**CITY OF ALBUQUERQUE  
PLANNING DEPARTMENT  
July 11, 2012  
DRB Comments**

**PROJECT # 1009321**

**APPLICATION # 12-70180**

**RE: *Tract A, Ainsworth Tract***

**PLAT OF
TRACT A-1 AND A-2
AINSWORTH ADDITION**

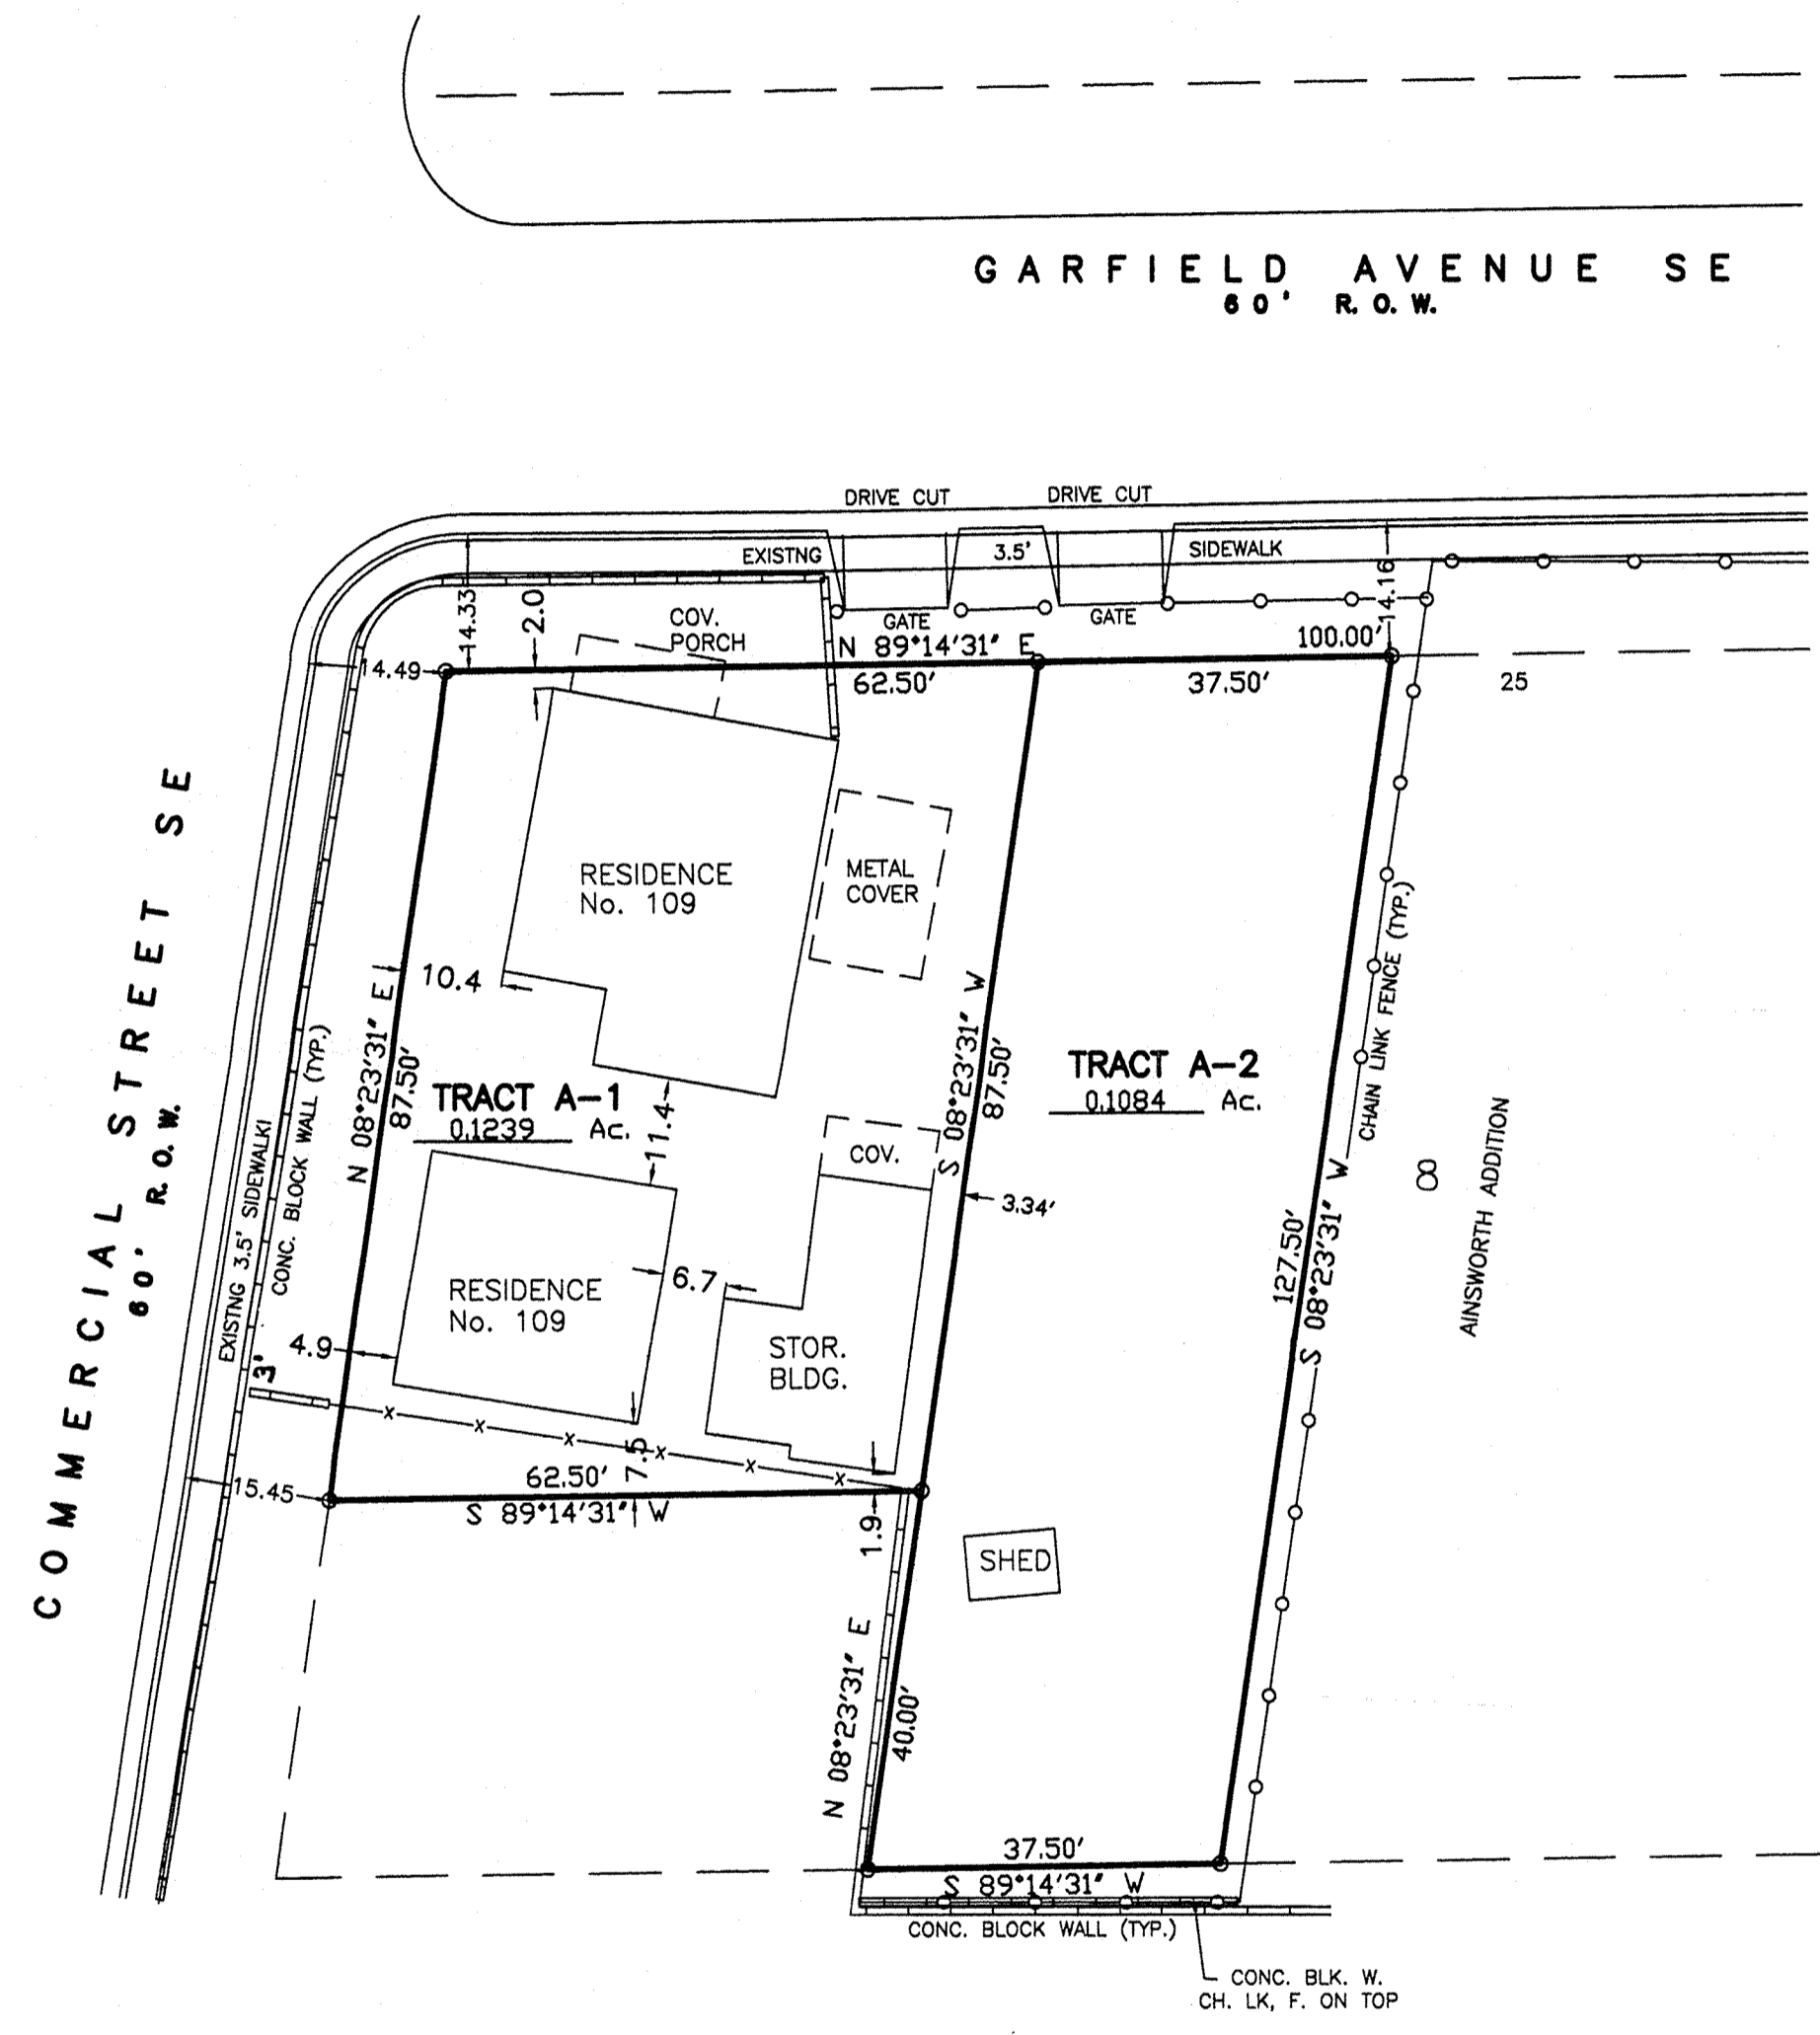
The site is zoned MR per the South Broadway Sector Development Plan, which corresponds to the R-1 district of the Zoning Code – minimum 5,000 sq ft lot area with a minimum 50 foot lot width for a house lot, and only one house per lot. The proposed plat would require variances to those requirements; however, uses listed as permissive in the R-2 Zone (except Group Training Homes) might be allowed as Conditional Uses – contact Zoning Enforcement.
